Subject: FW: A/50/20/PL - Variation of Condition 2 in respect of A/51/18/PL, Pound Place, Roundstone Lane, Angmering, BN16 4AL

Environmental Health.

Noise Report.

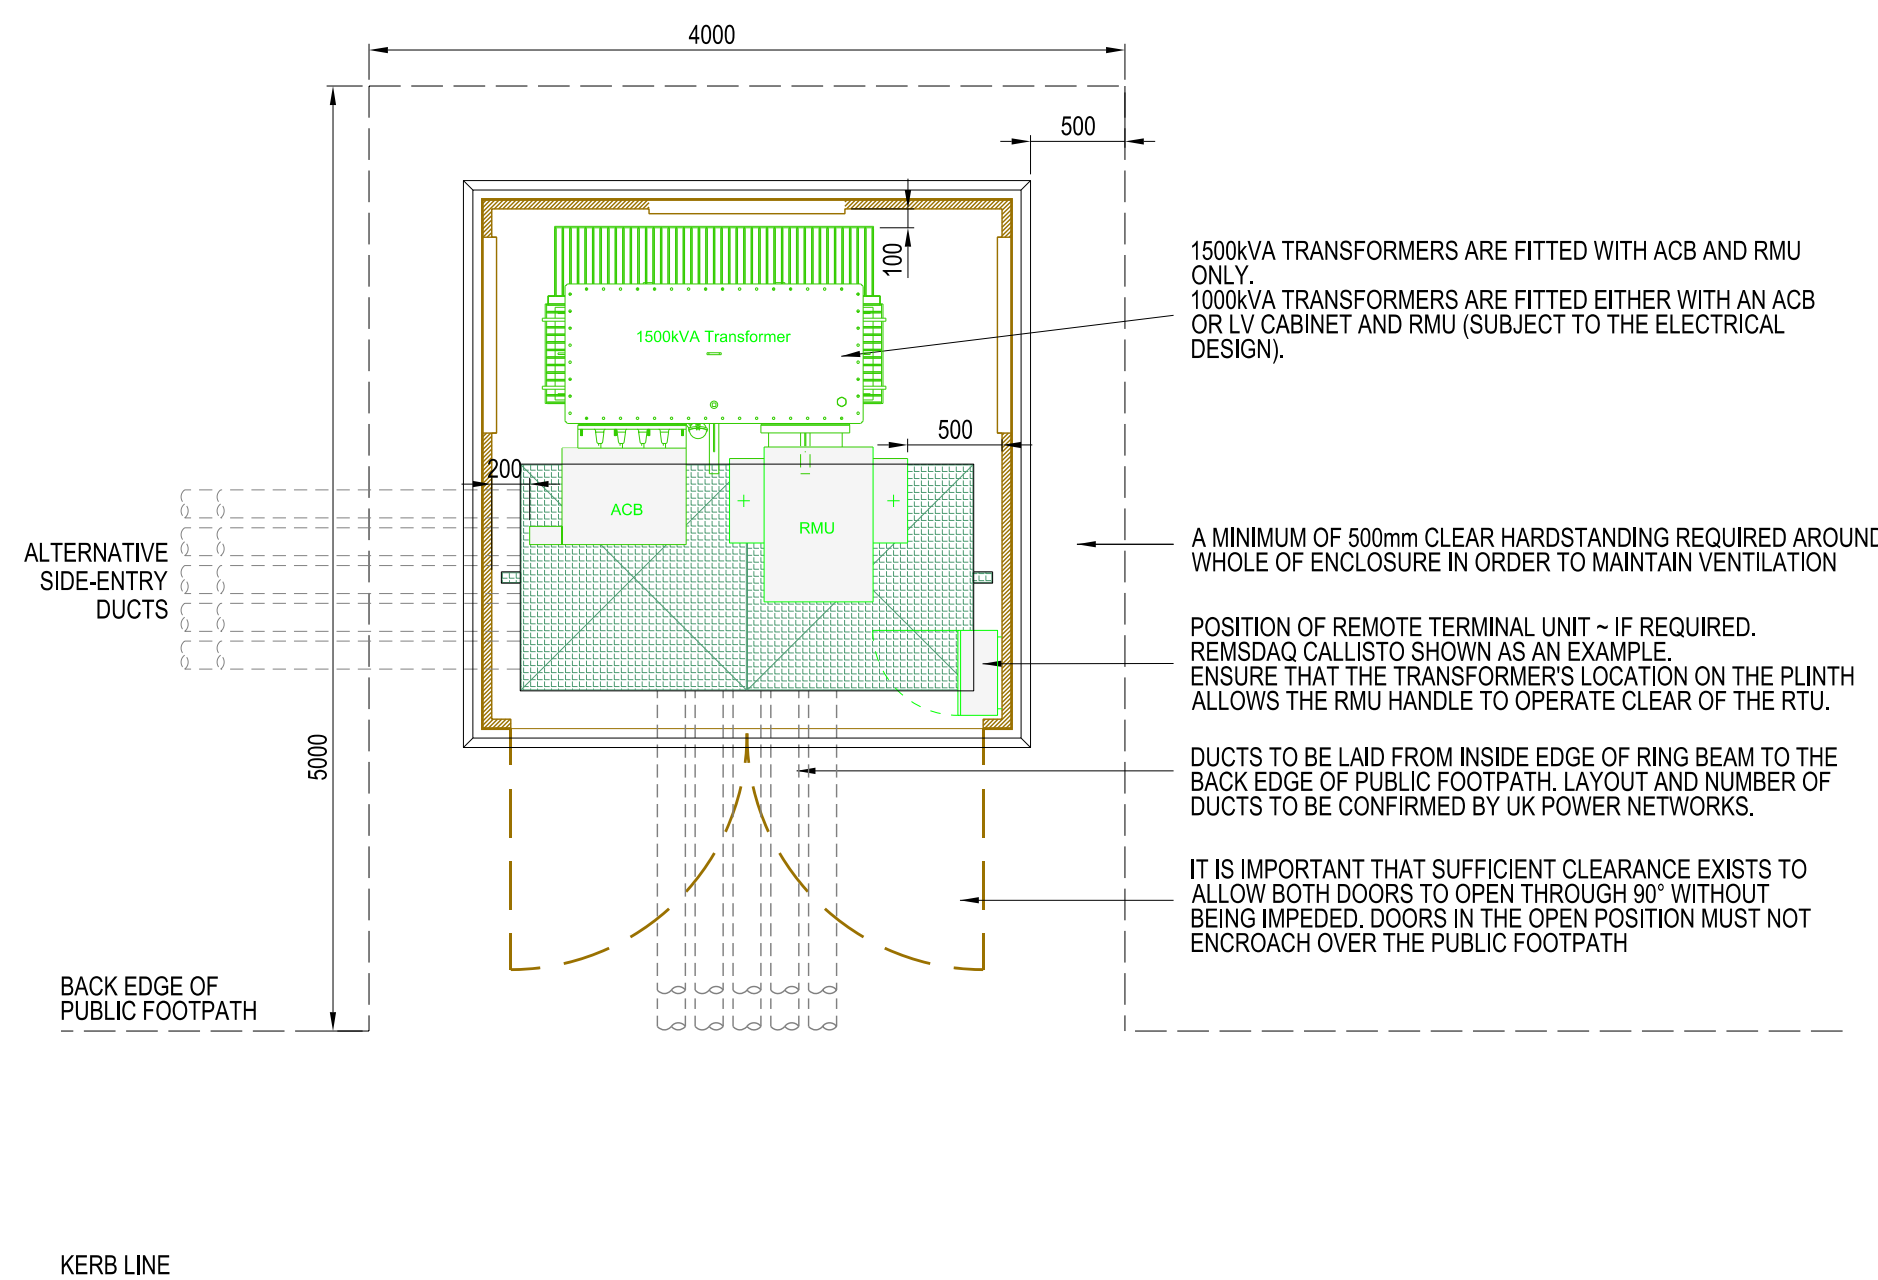
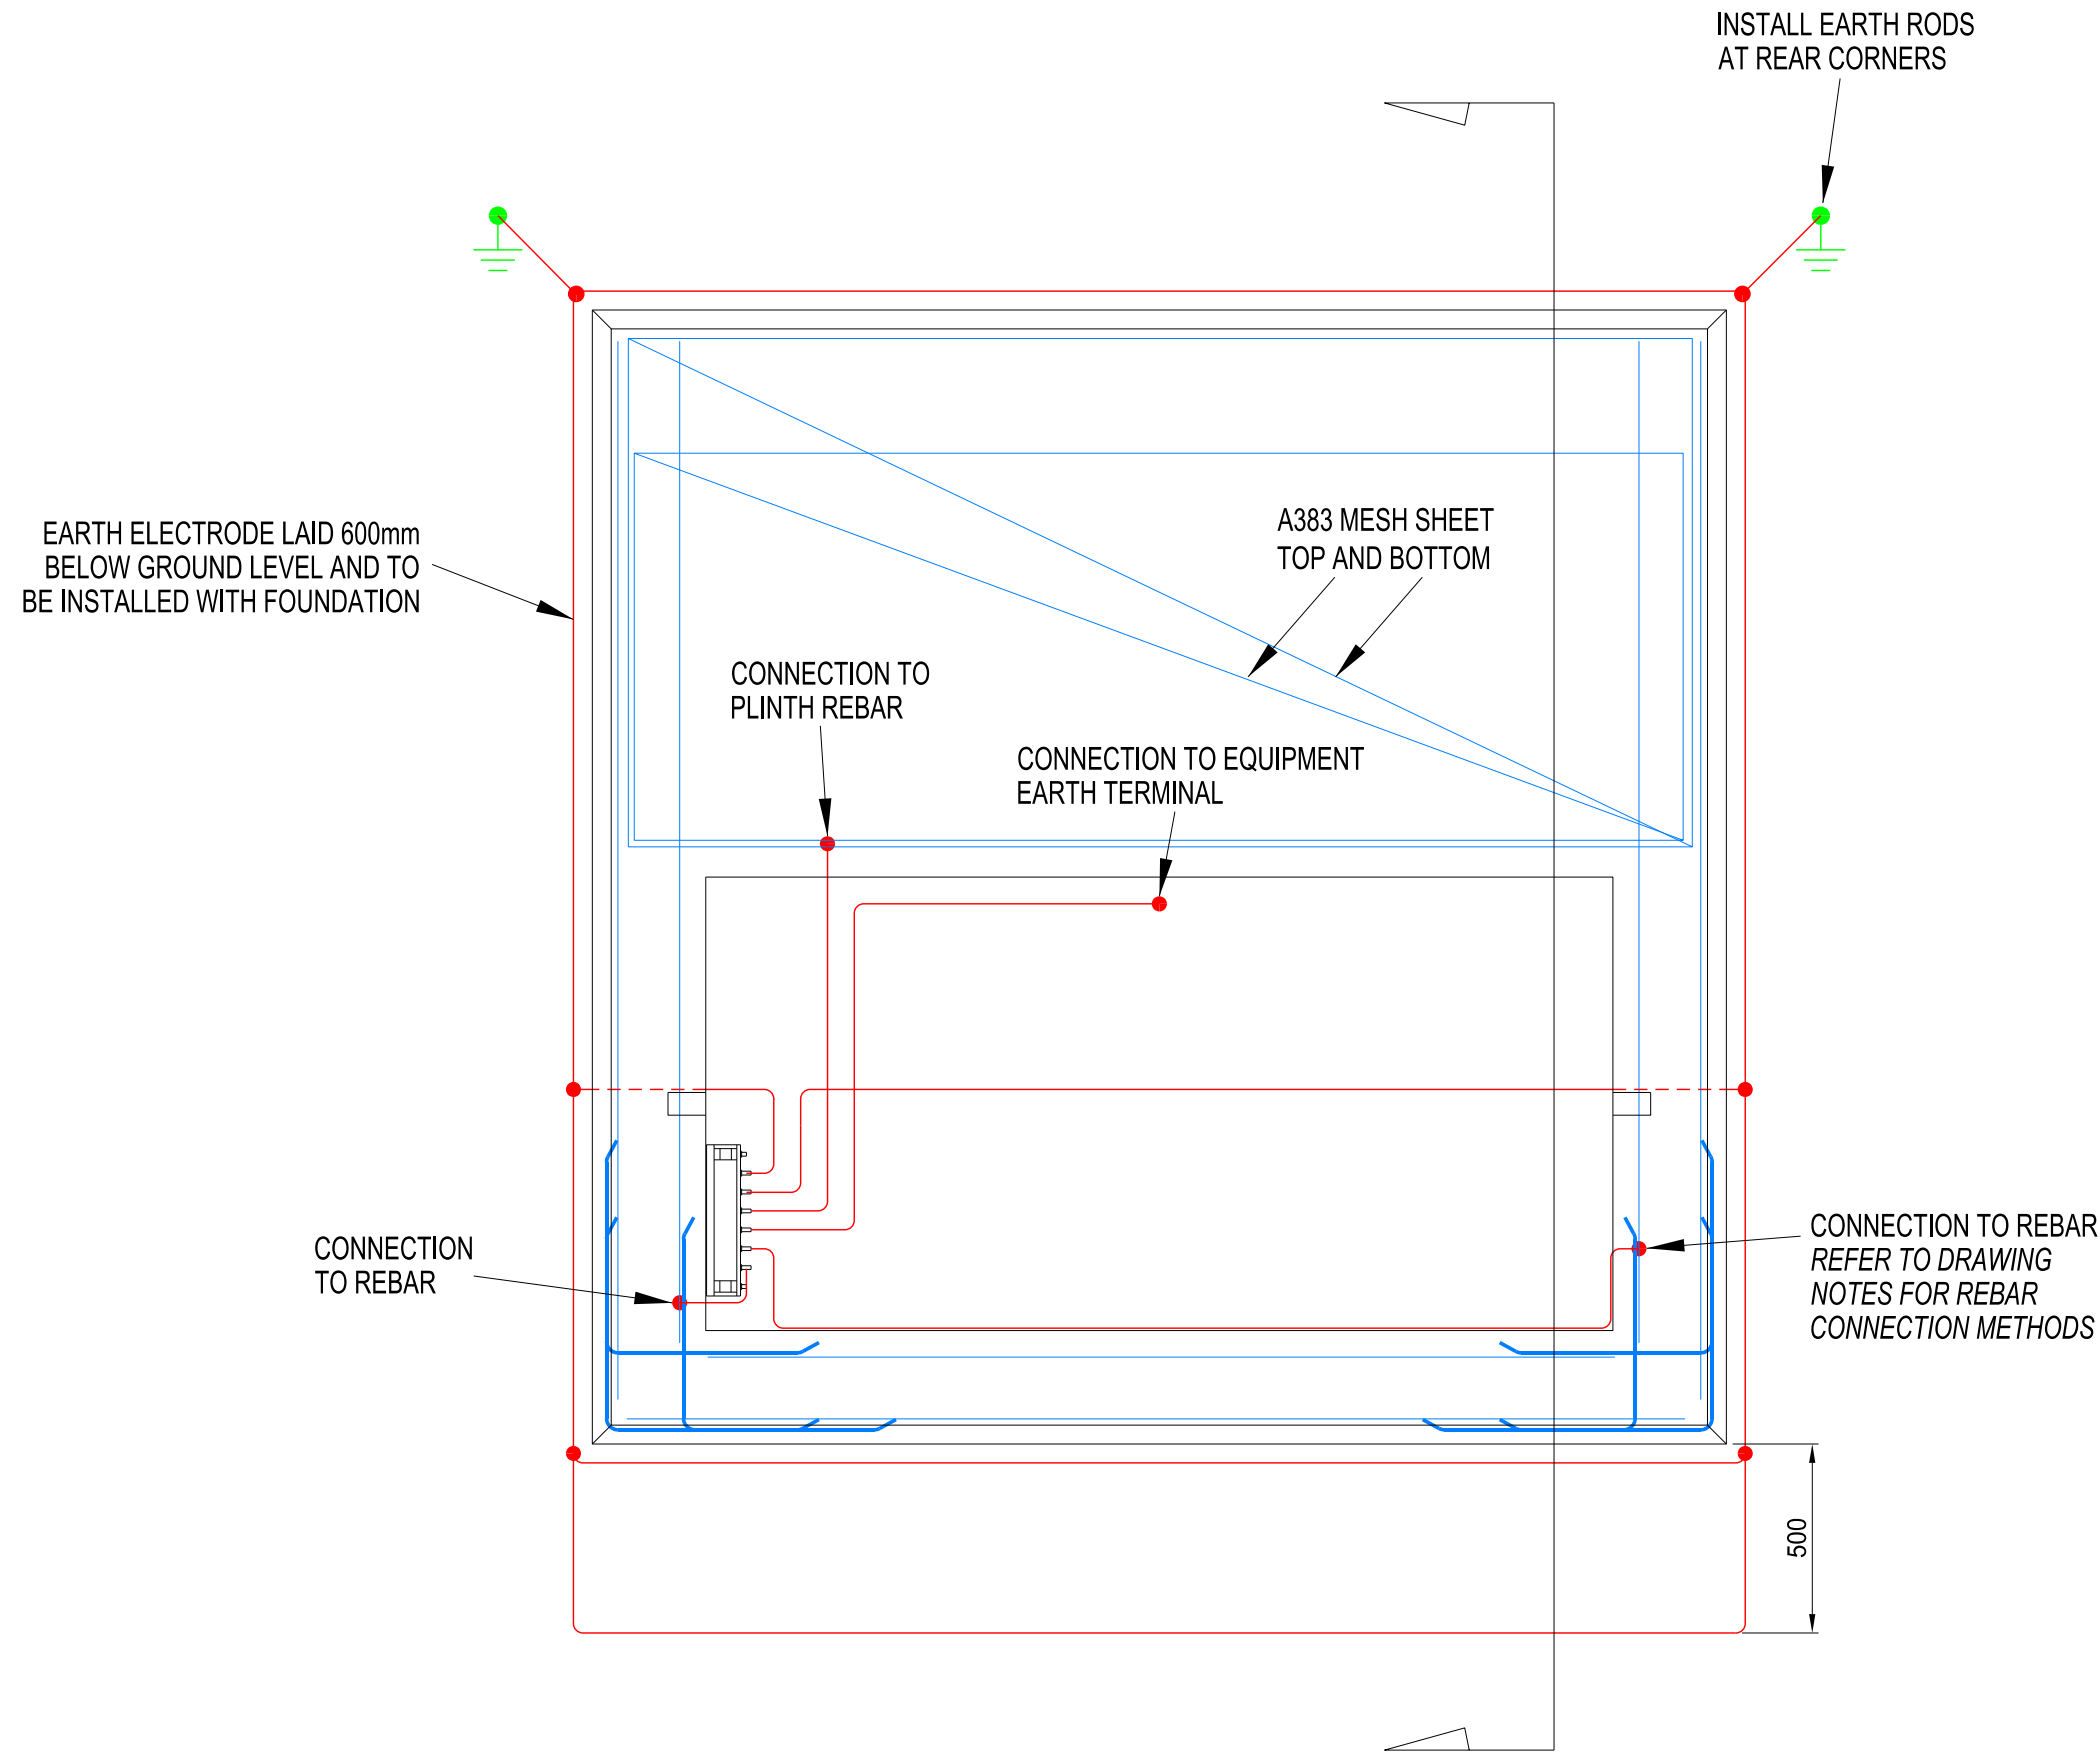
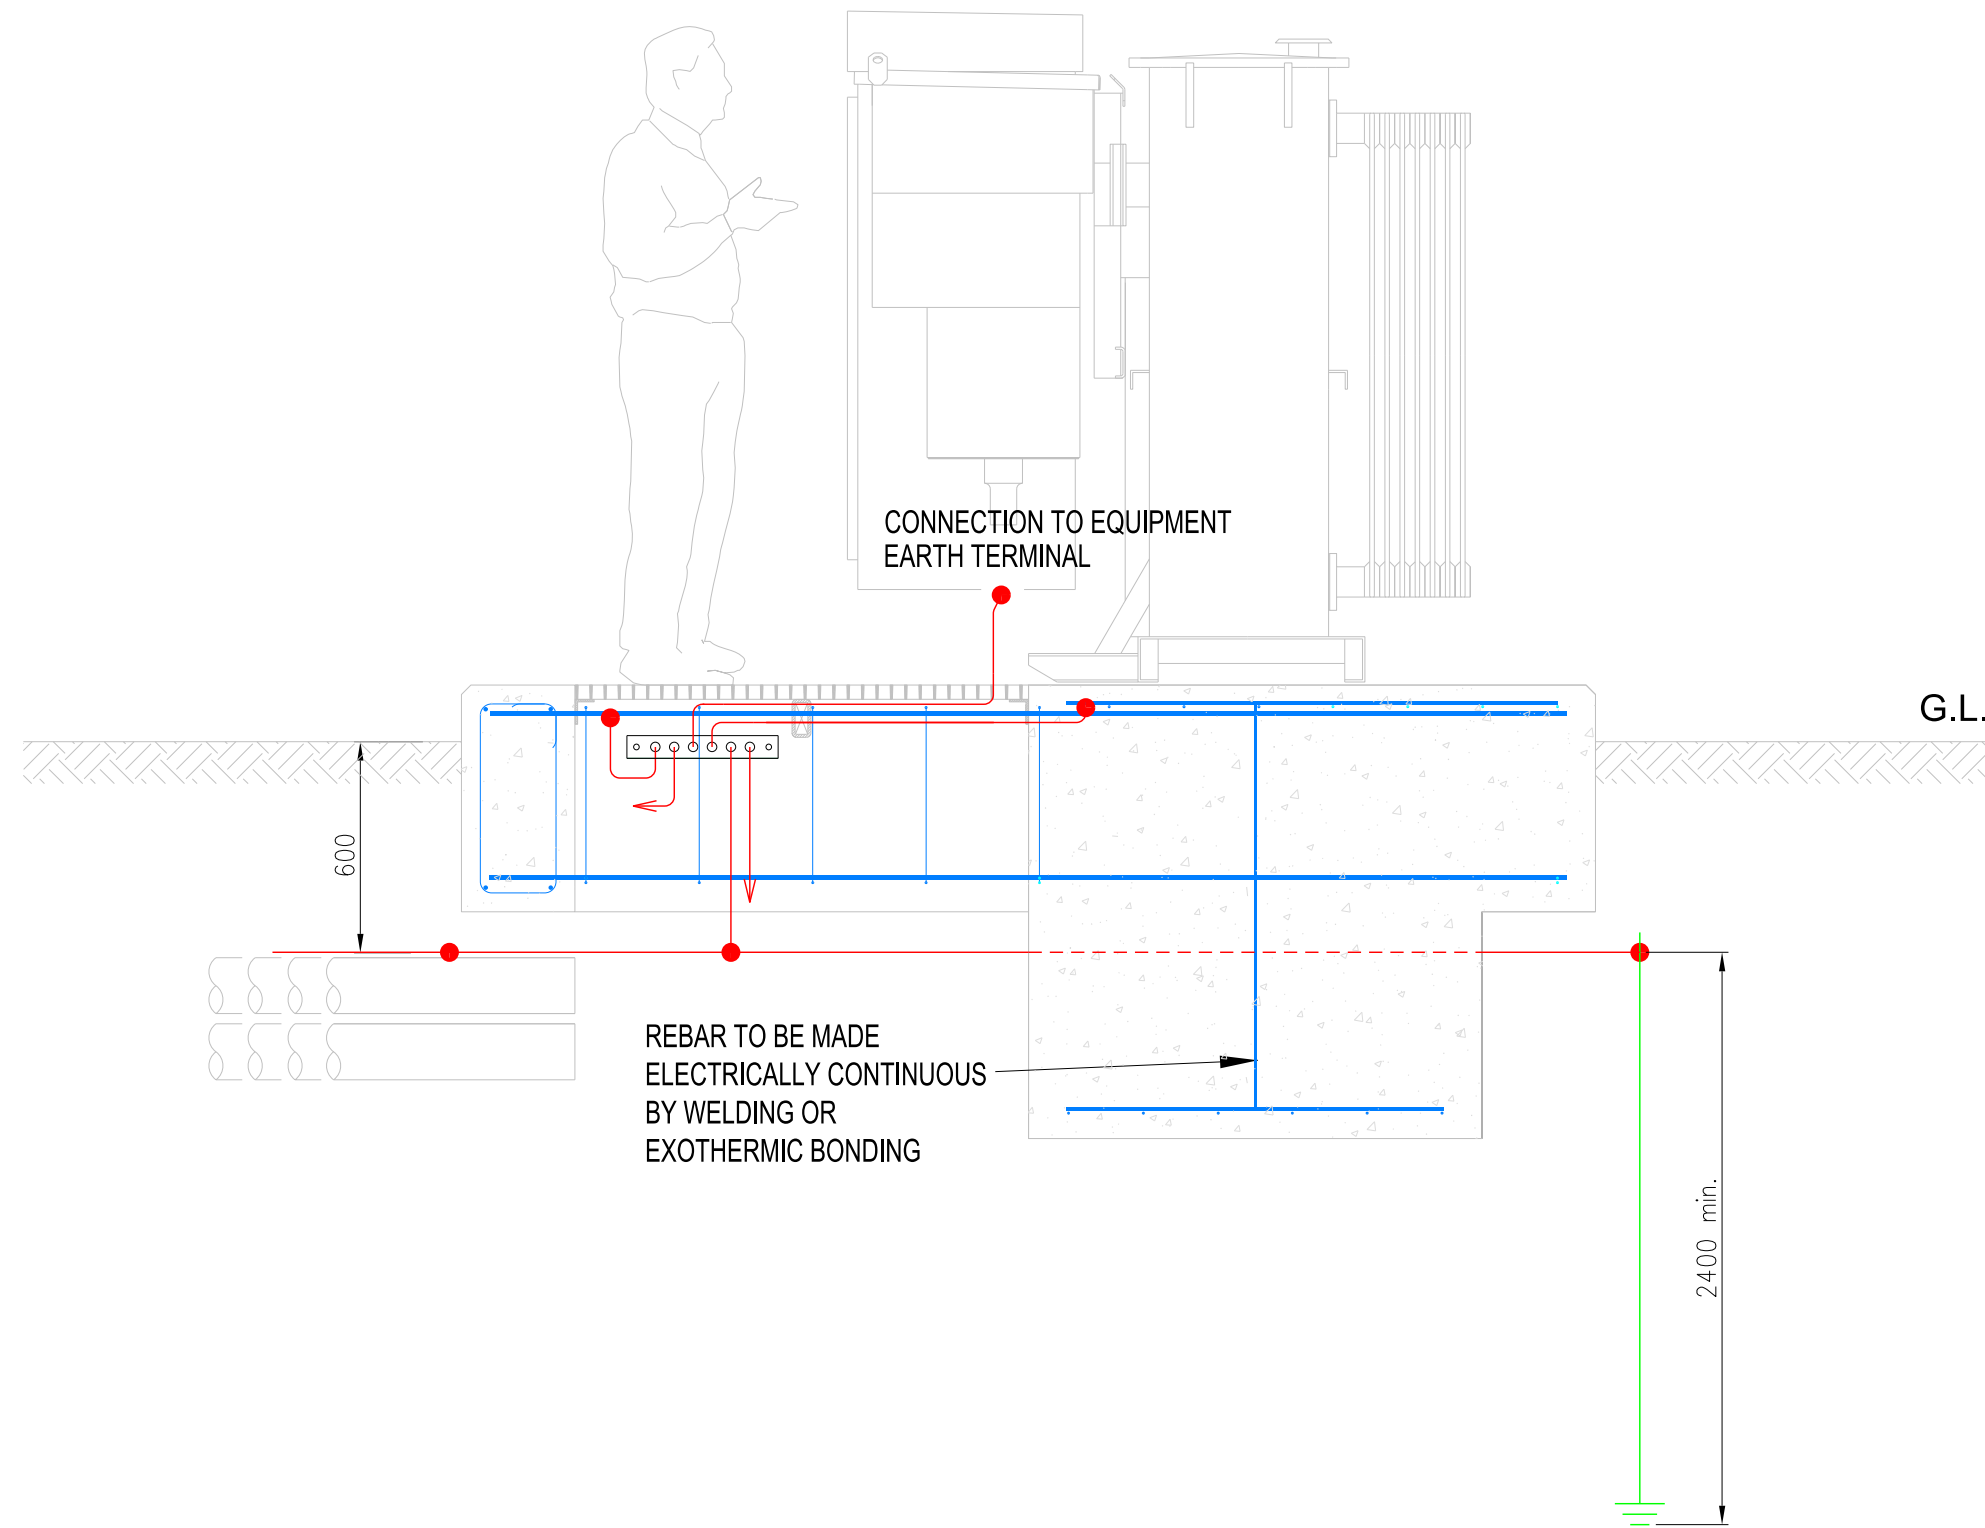
1. Prior to the first use of the electricity substation, an acoustic report assessing the impact shall be submitted to and approved in writing by the Local Planning Authority. The report shall address the issue of noise (including low frequency noise) and vibration from the station to ensure that there is no adverse effect to residential or commercial properties

For residential accommodation, the scheme shall ensure that the low frequency noise emitted from the substation is controlled so that it does not exceed the 'Low Frequency Criterion Curve' for the 10 to 160 Hz third octave bands inside residential accommodation as described in the DEFRA funded University of Salford Manchester guidance document entitled 'Procedure for the Assessment of Low Frequency Noise Complaints' (NANR45 Rev.1 – December 2011).

The electricity substation equipment shall be maintained in a condition so that it complies with the levels and mitigation measures specified in the approved acoustic report, whenever it is operating. After installation of the approved plant, no new plant shall be used without the written consent of the Local Planning Authority.
